BANORA POINT & DISTRICT RESIDENTS ASSOCIATION Inc.

Friday, 1 April 2011

**Re: DEP Reference 09_0166
Altitude Aspire 321 Lot Subdivision, Fraser Drive, Terranora.**

This is an objection to the application in its present form, primarily on grounds of unsatisfactory and unresolved access.

PLAN SHOWING
PROPOSED SUBDIVISION LAYOUT
& DESIGN CONTOURS

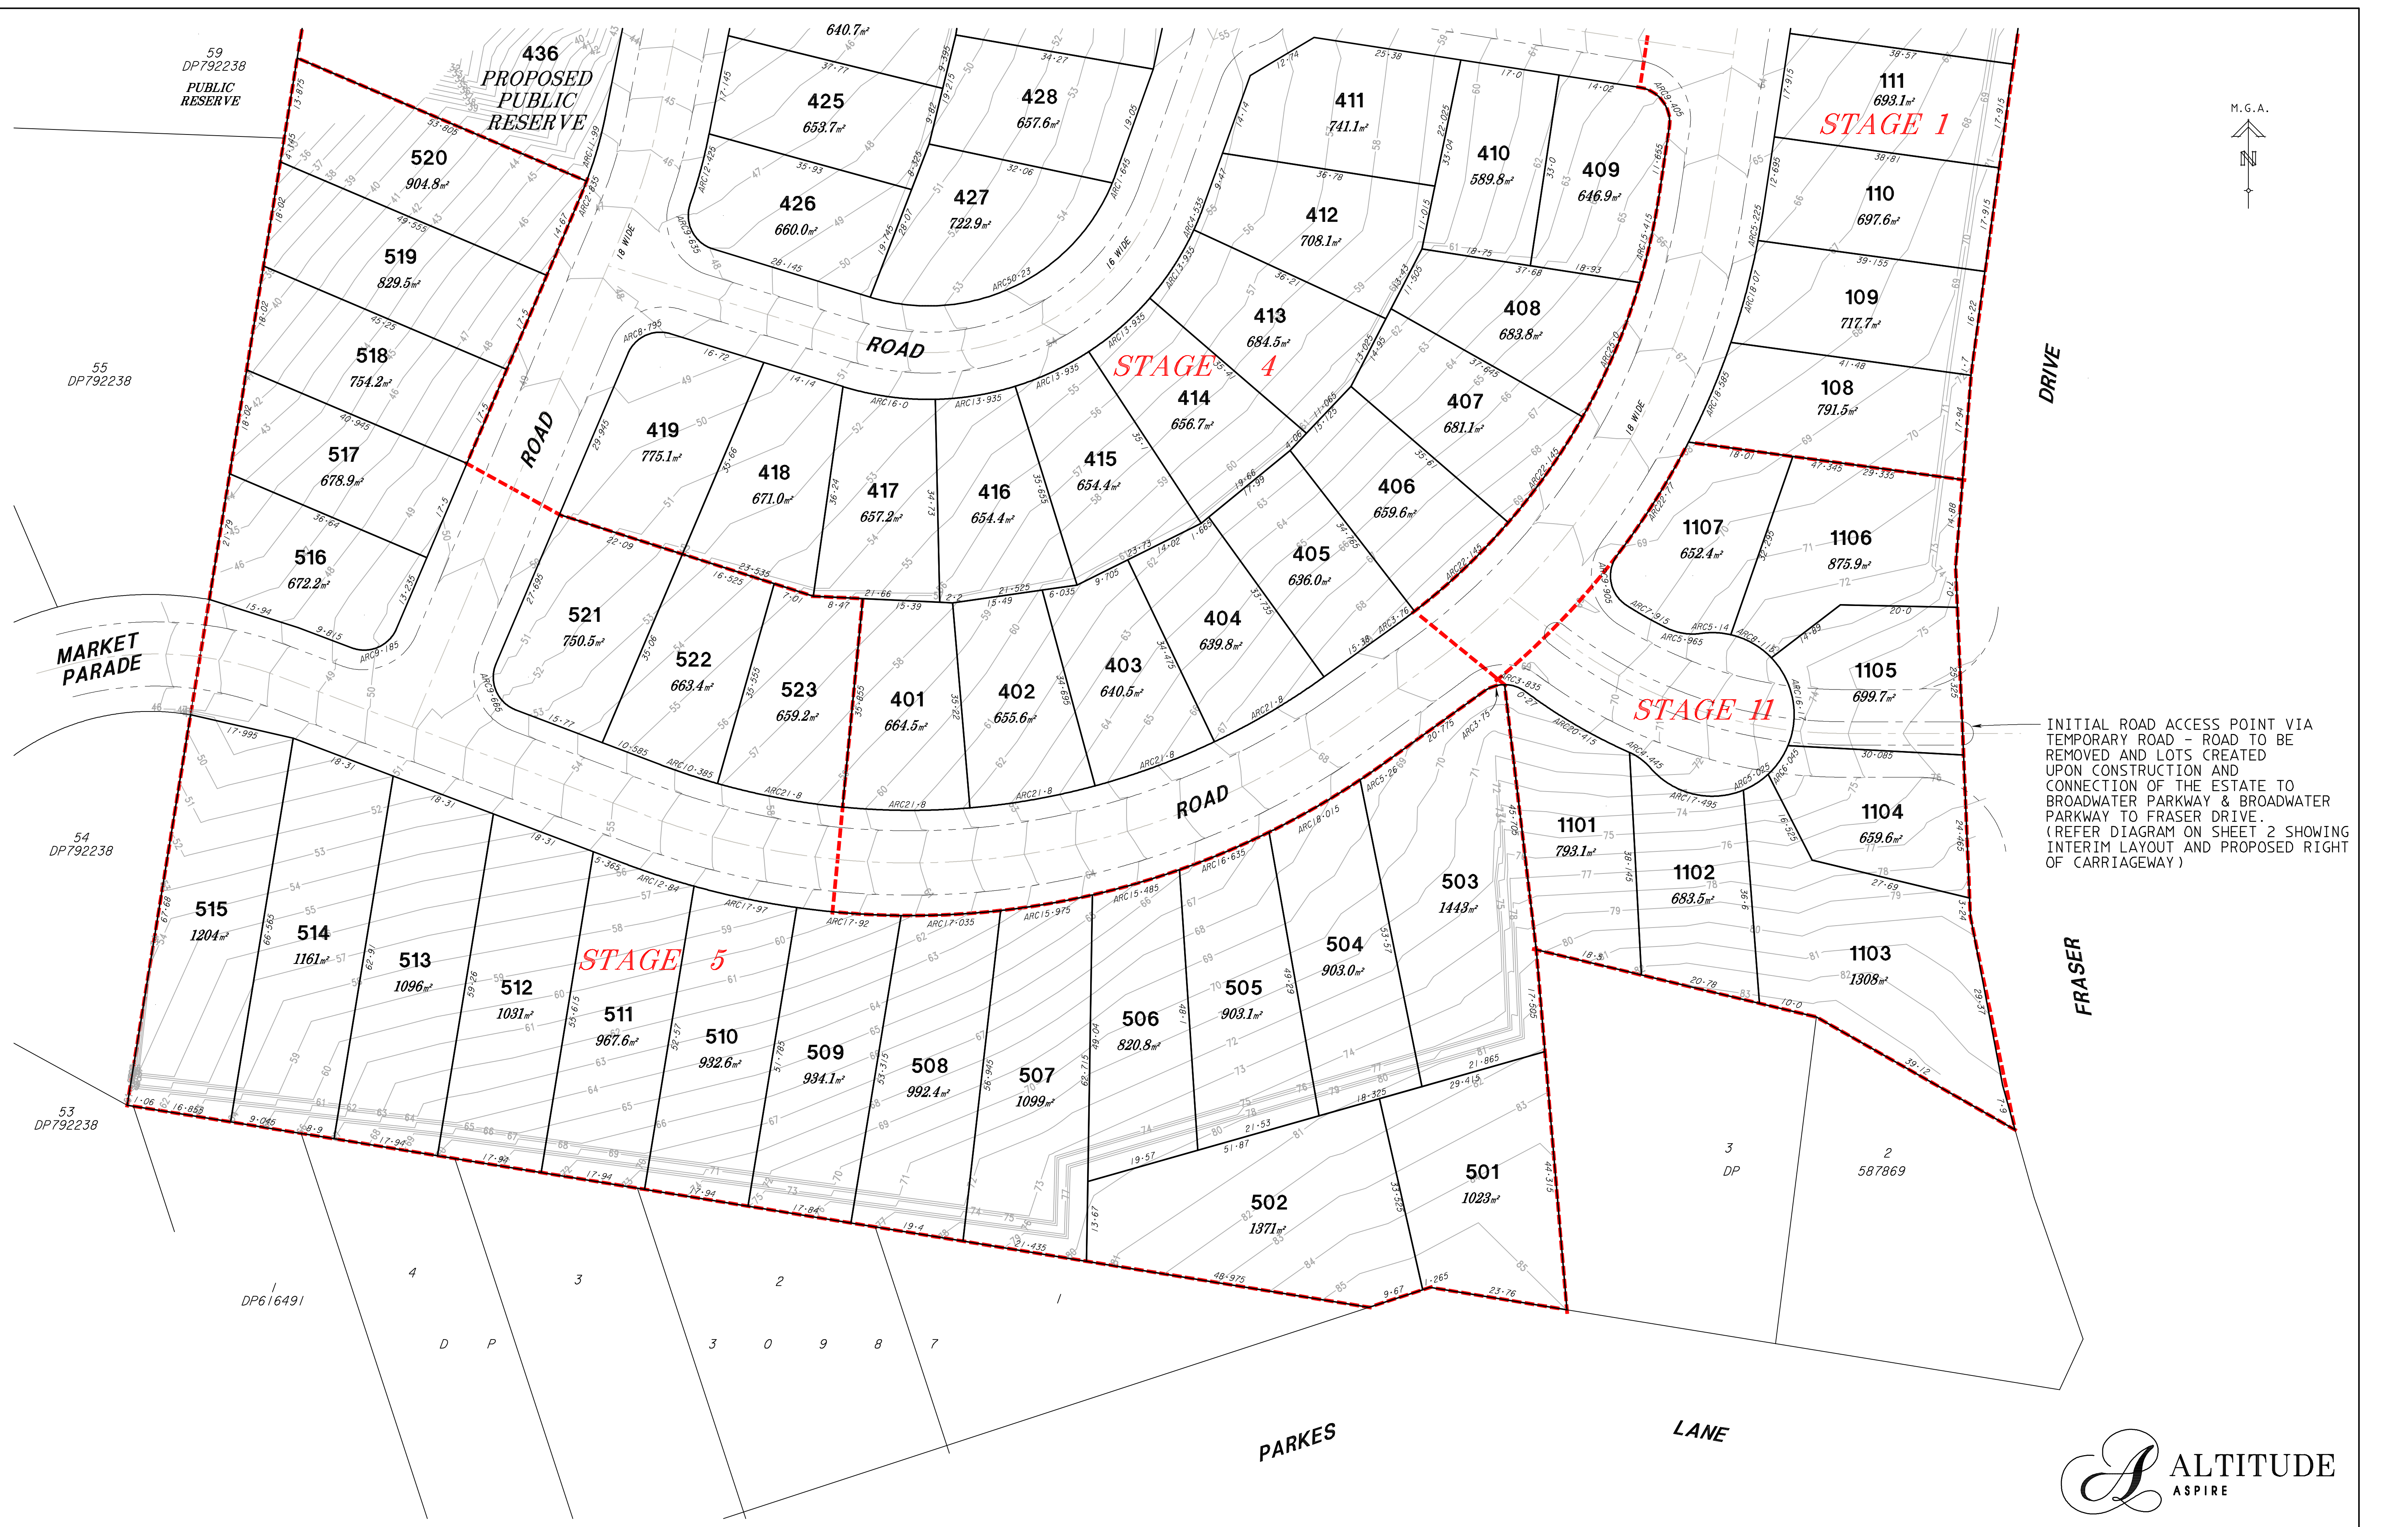
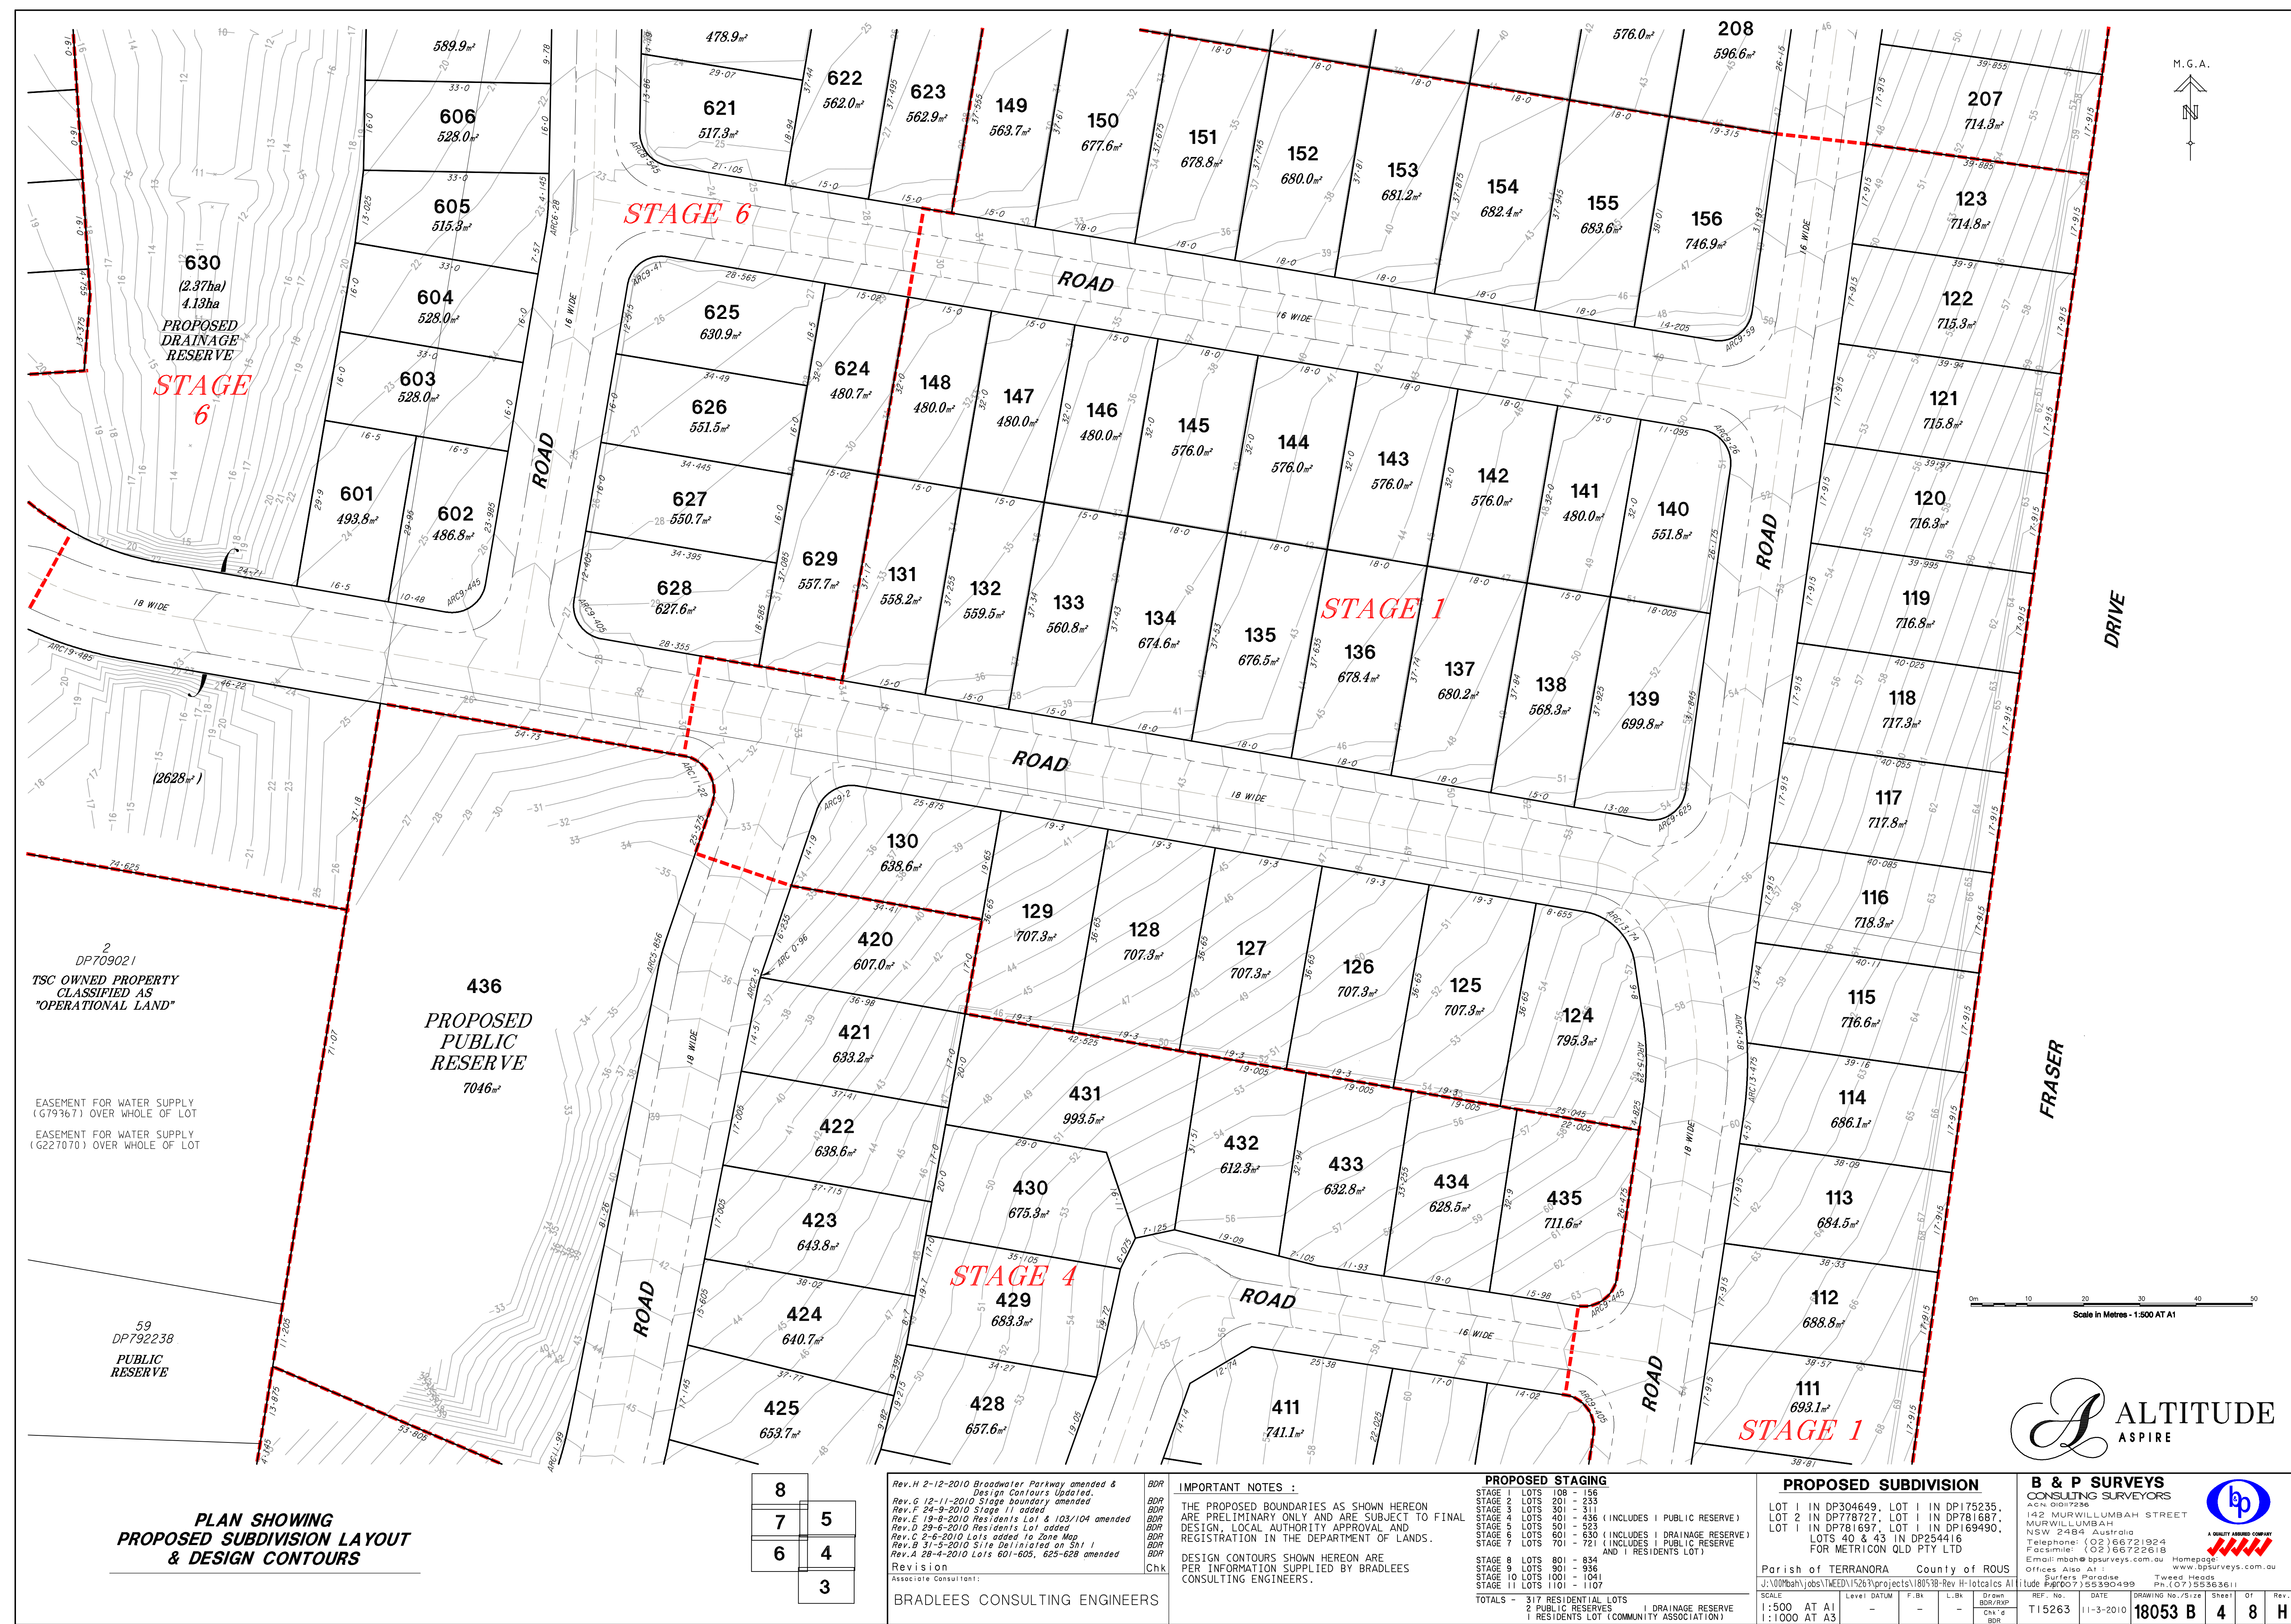
Instead, the application proposes a "temporary" link with Fraser Drive via a Right of Carriageway (ROW) at the most southerly point of their development. During the development of Altitude Aspire, other links with roads have been proposed (Parkes Lane and Market Parade). The final stage of Altitude Aspire, Stage 11, is the closure of the ROW.

1. Access to and from the estate has not been determined.
2. The access corridor proposed under Tweed LEP 2000 appears to have been abandoned without justification.
3. No costings for the road can be assessed in the absence of design plans.
4. Method of payment for the road and time of construction are not known and no commitment for construction made.
5. The proposed "temporary" access road via a ROW to Fraser Drive is unsatisfactory. This will be the only access to the estate until Stage 5 when an equally unsatisfactory link is proposed to Market Parade.
